**KIRKLEES METROPOLITAN COUNCIL
INVESTMENT & REGENERATION SERVICE**

**DELEGATED DECISION TO DETERMINE APPLICATIONS FOR
CONSENT, AGREEMENT OR APPROVAL REQUIRED BY CONDITION**

Reference No:	2024/44/92862/E
Site Address:	Land at, Abbey Road, Shepley, Huddersfield, HD8 8DY
Description:	Discharge of details reserved by conditions 3 (perimeter boundary treatment), 10 (cycle parking) and 14 (highways specification) of previous Reserved Matters approval 2019/91638 for erection of 27 dwellings pursuant to outline permission 2017/92233 for erection of up to 34 dwellings
Recommending Officer:	Victor Grayson

Officer Report

Client:	Job No:	
Scottfield Ltd	18,019	
Project:		
Abbey Road, Shepley		
Title:		
Western Boundary and Plot 27 Wall Proposals		
Date:	Scale:	Checked by:
07/19/21	As indicated	BBA1
Drawing No:	Drawn By:	Revision:
00-111	MRC	B

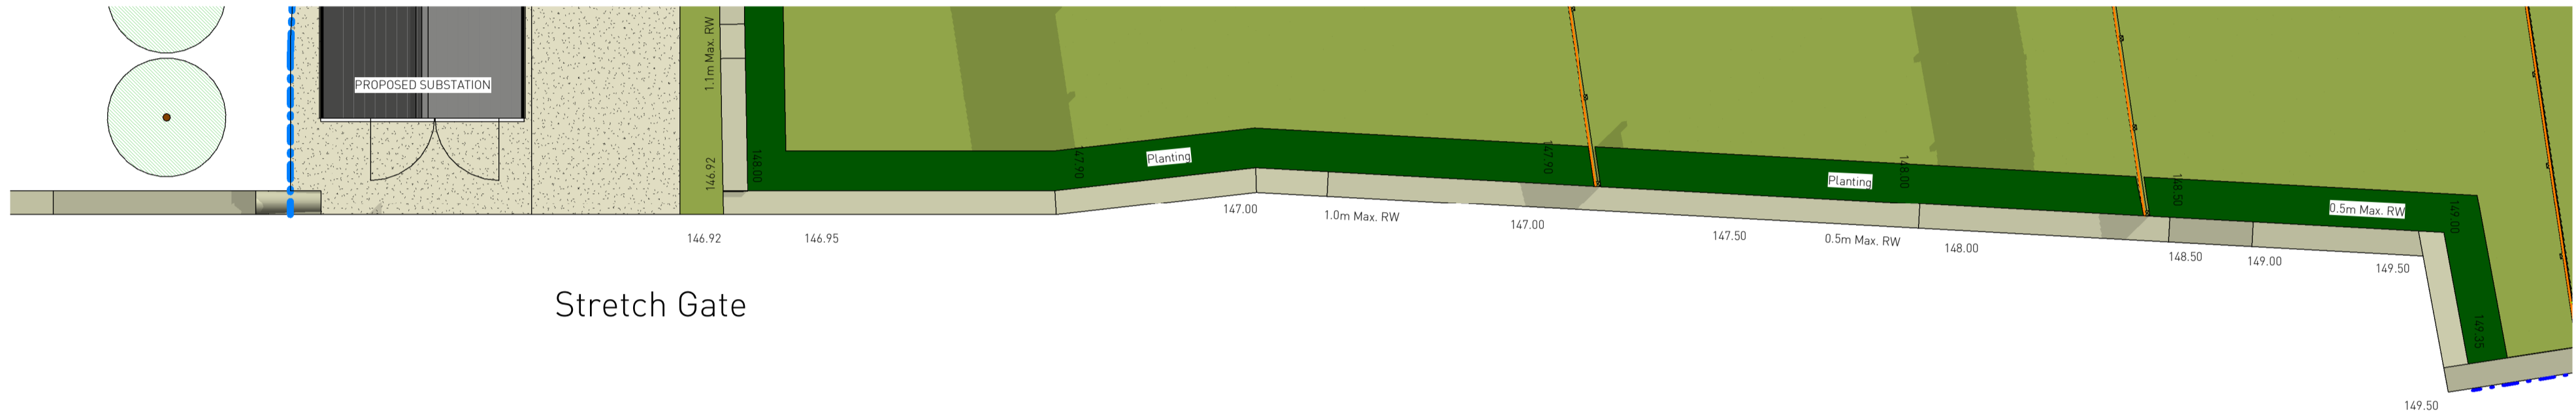
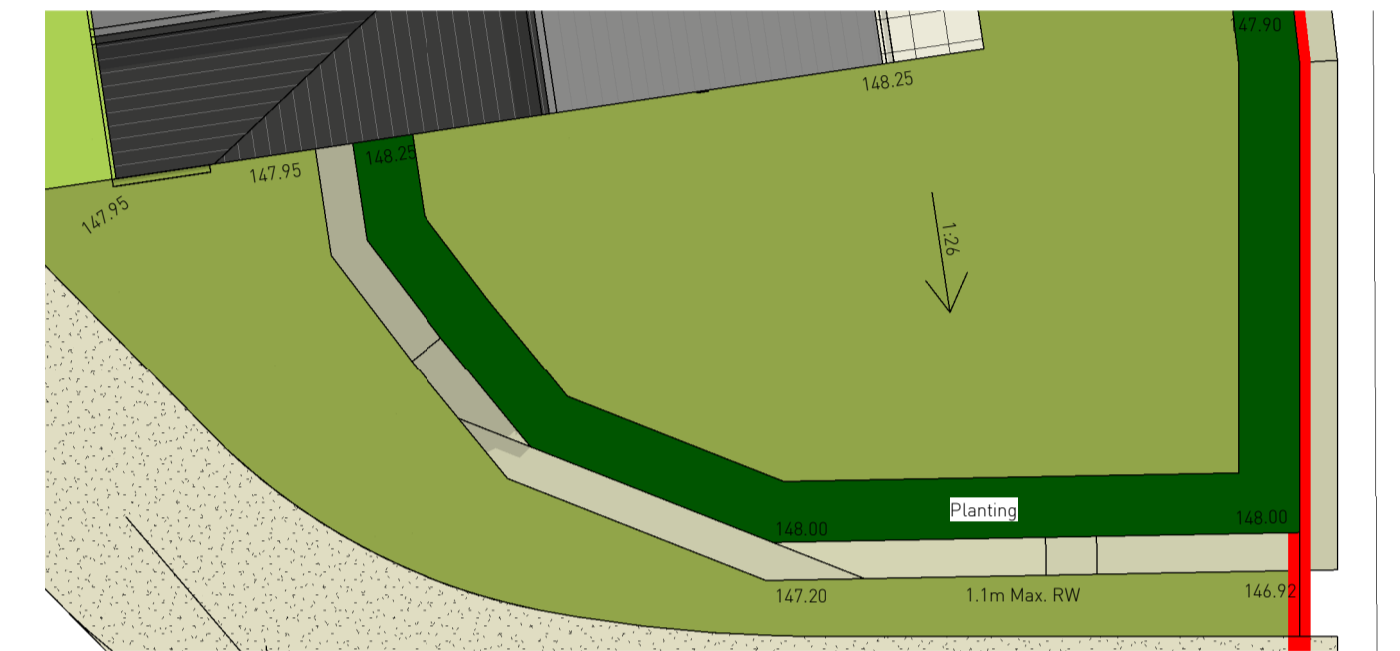
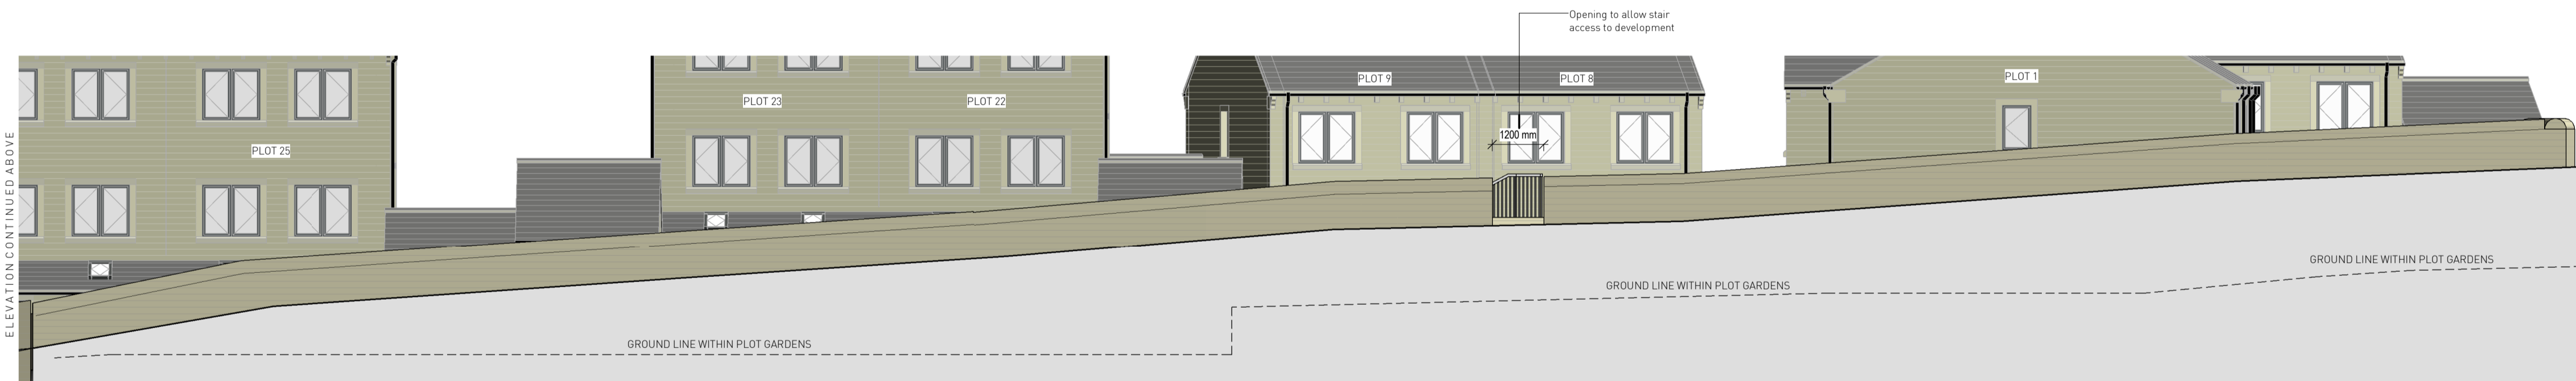
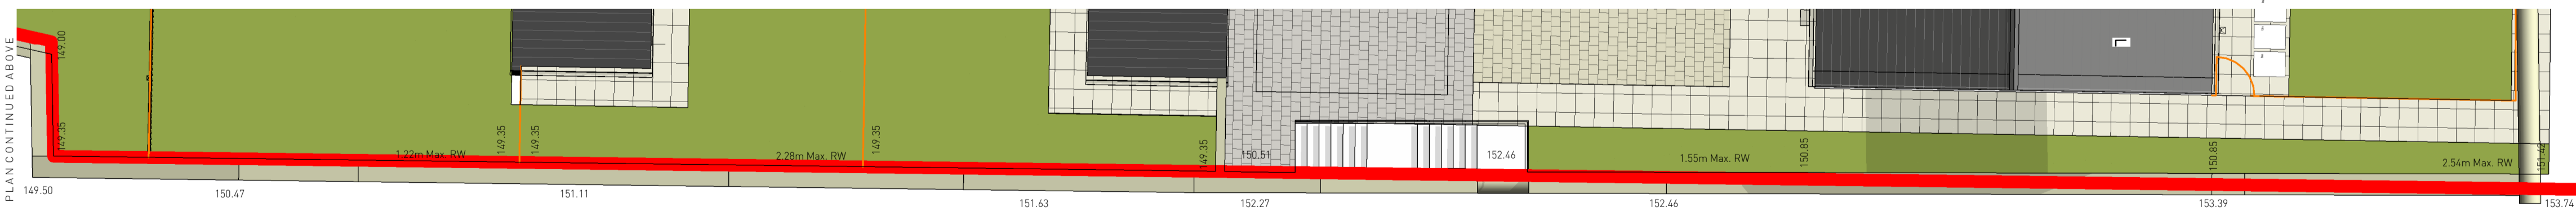
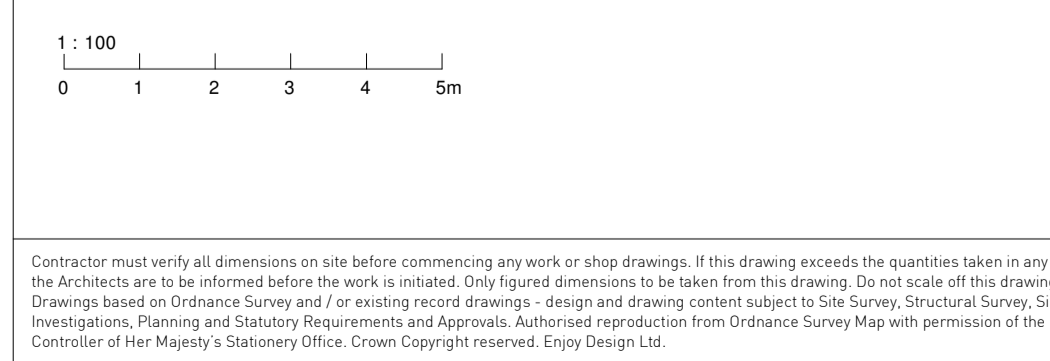
For this current Discharge of Conditions application, the applicant has submitted a drawing titled “Western Boundary and Plot 27 Wall Proposals” (drawing 00-111 rev B) pursuant to condition 3. This drawing had already been submitted and approved under application 2022/90245. It shows boundary treatments to the site’s western boundary and around the side of plot 27 (now 31 Tailors Green). It does not show boundary treatments for the rest of the site’s perimeter.

The applicant has not submitted an assessment of the works required to repair/replace the site’s existing stone perimeter wall, or a timescale for the implementation of the boundary treatment. This information is specifically required by condition 3.

Of note, details of the part of the site’s perimeter wall (along the western edge of the site, to Stretch Gate) have been approved under permission 2022/90245. However, as noted in the council’s decision notice of 12/12/2023, part of that wall had been built higher than shown in the drawings approved under that permission. That decision notice also confirmed that the materials used in the wall are acceptable. For the avoidance of doubt, given that an approval (2022/90245) has been issued for the boundary along the western edge of the site (to Stretch Gate), it is not considered necessary for boundary treatment details to be submitted pursuant to condition 3 for that part of the site.

For this current Discharge of Conditions application, the applicant has not submitted the information required by condition 3. It has therefore not been demonstrated that highway safety, visual amenity and the character of the surrounding area would be maintained, and an approval cannot be issued pursuant to condition 3.

Condition 3 (perimeter boundary treatment) – You have submitted a drawing titled “Western Boundary and Plot 27 Wall Proposals” (drawing 00-111 rev B) pursuant to condition 3. This drawing (which had already been submitted and approved under application 2022/90245 in relation to the site’s western boundary and around the side of plot 27 (now 31 Tailors Green)) does not show boundary treatments for the rest of the site’s perimeter. Furthermore, you have not submitted an assessment of the works required to repair/replace the site’s existing stone perimeter wall, or a timescale for the implementation of the boundary treatment. This information is specifically required by condition 3.

TITLE	
SECTION 38 LAYOUT	
PROJECT	
ABBEY ROAD NORTH, SHEPLEY	
CLIENT	
CAMSTEAD	
DRAWING STATUS	
FOR CONSTRUCTION	
Scale	Date
1:500 @ A1	APR 19
Drawn	Chk.
DJG	TC
Rev. No.	Rev.
1305/11/02.01	N

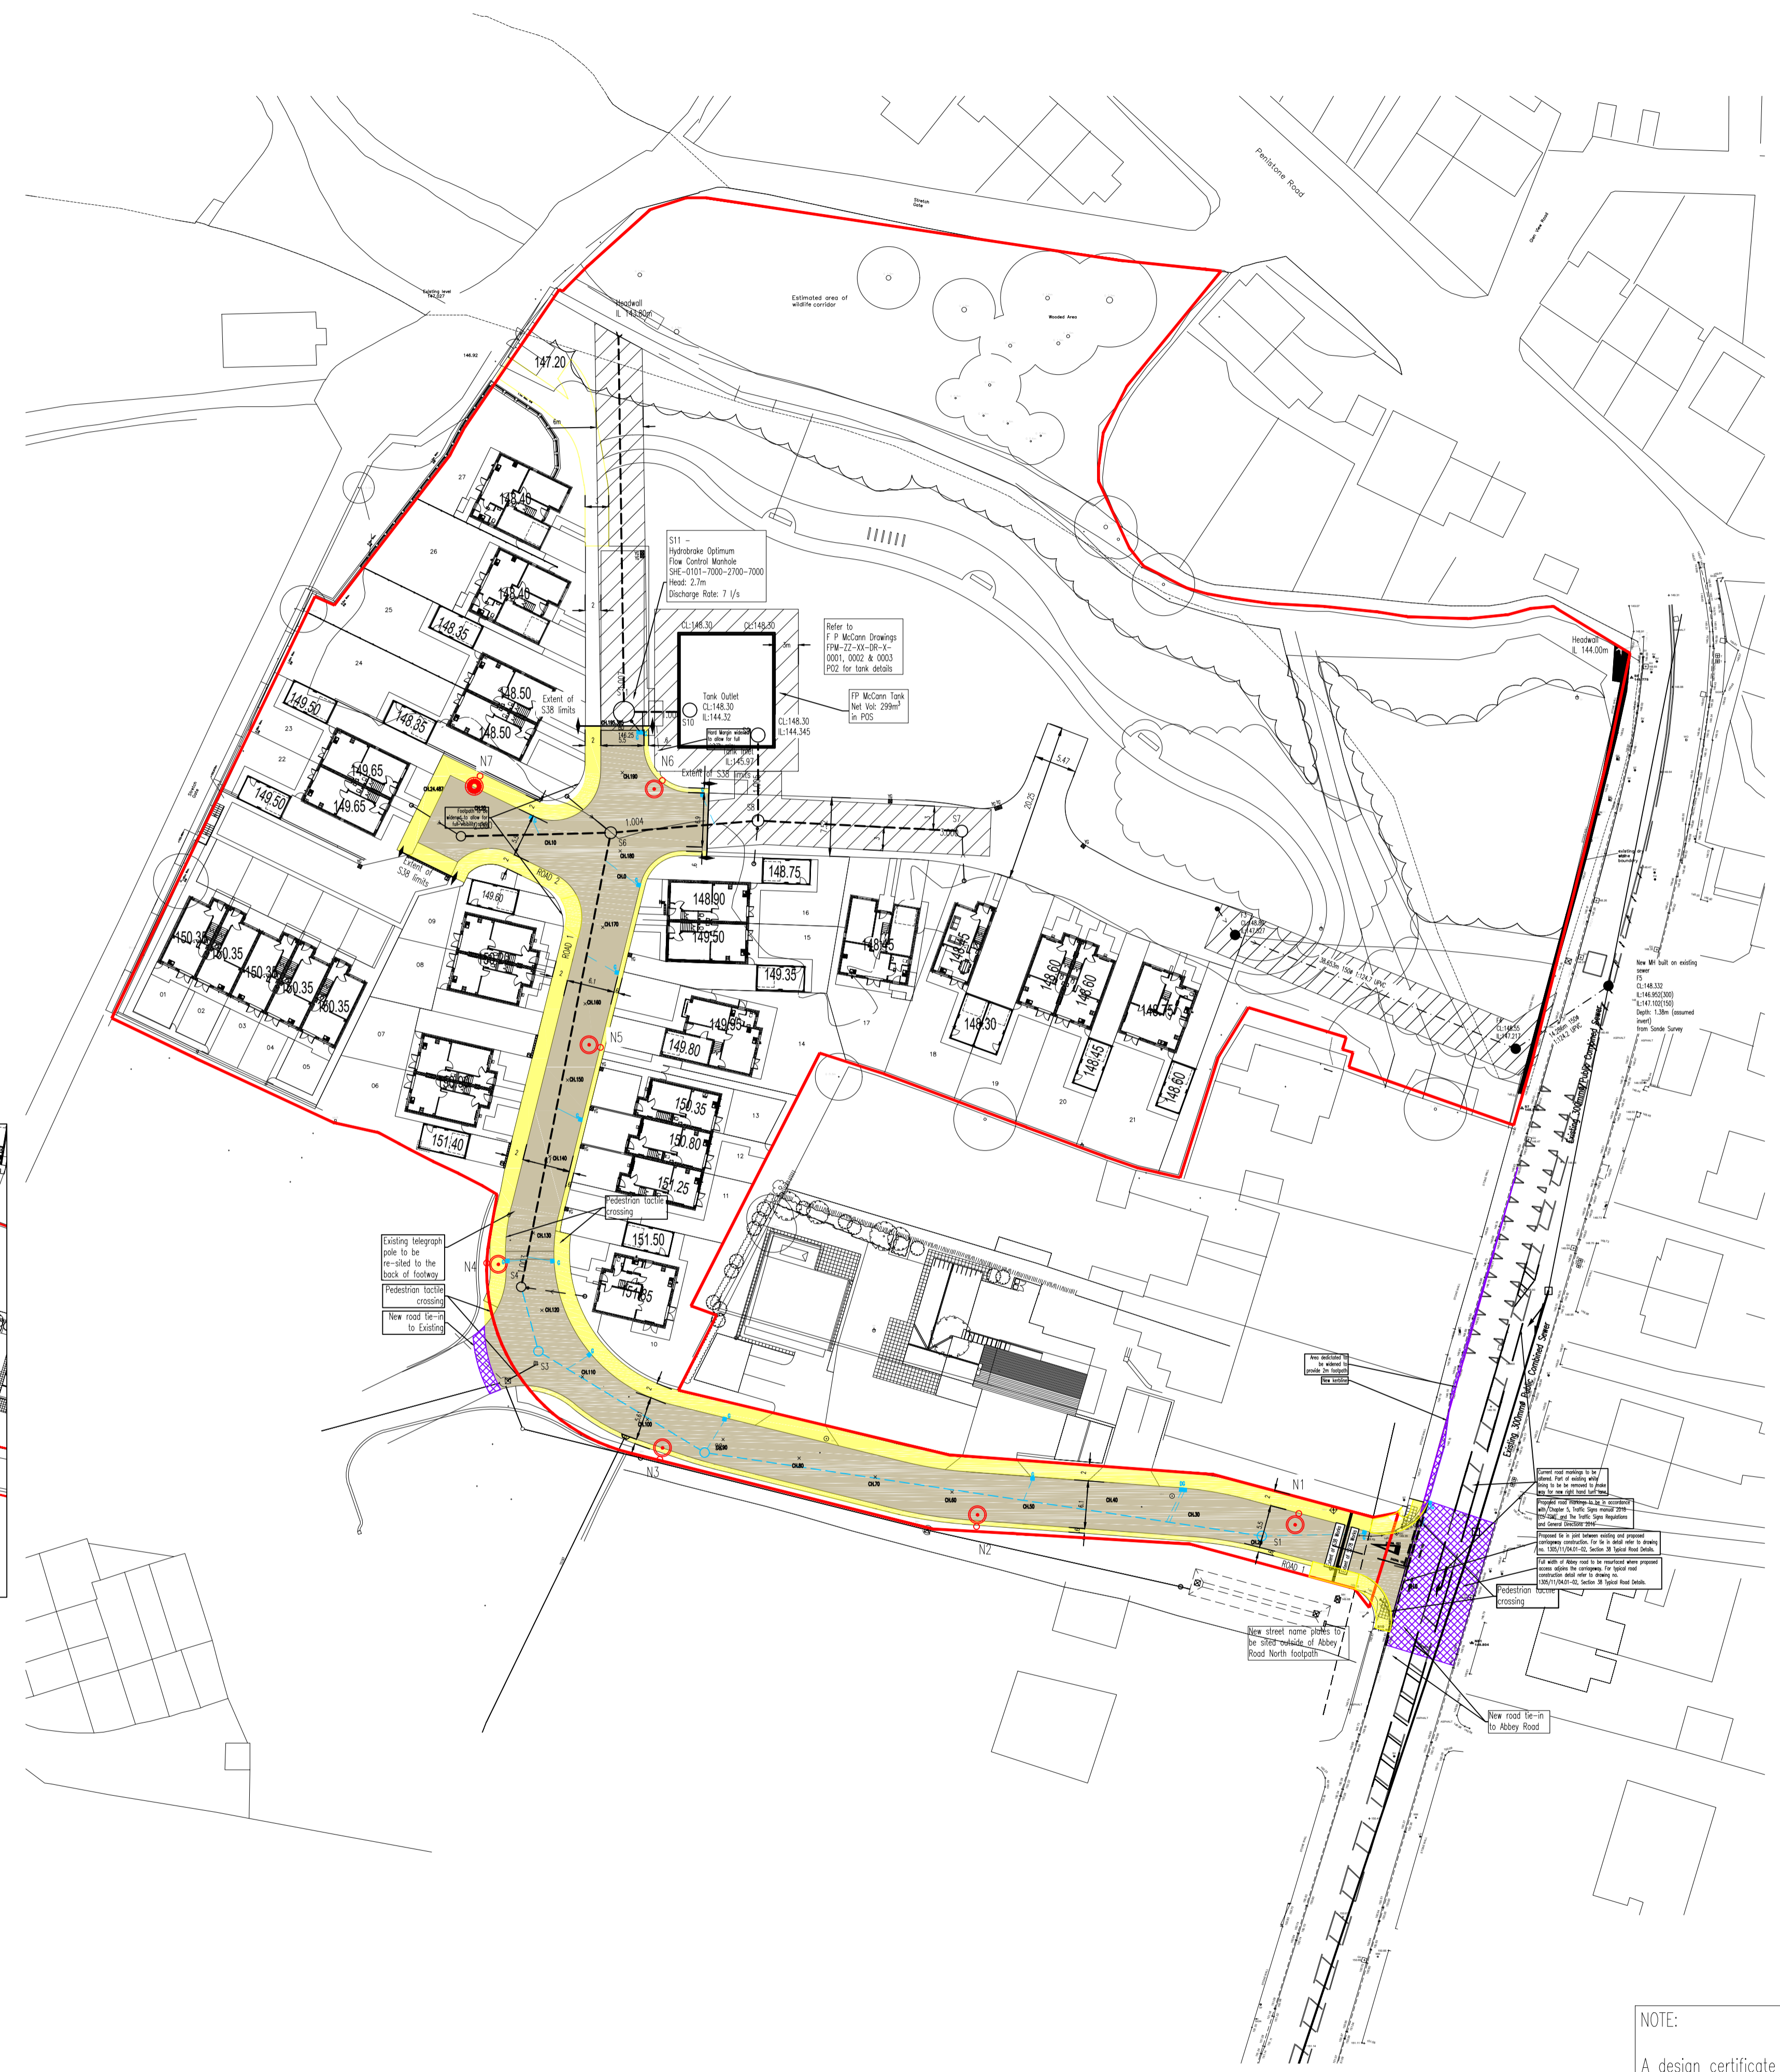
The applicant has submitted a Section 38 Layout (drawing 1305/11/02.01 rev N) pursuant to condition 14. While this provides a plan view of the proposed highway works (including locations of gullies etc), it does not provide a full specification (including sections, full details of drainage features and surface materials etc).

It has therefore not been demonstrated that highway safety and safe pedestrian access to and from the site would be provided and maintained.

Condition 14 (highways specification) – You have submitted a Section 38 Layout (drawing 1305/11/02.01 rev N) pursuant to condition 14. While this provides a plan view of the proposed highway works (including locations of gullies etc), it does not provide a full specification (including sections, full details of drainage features and surface materials etc).
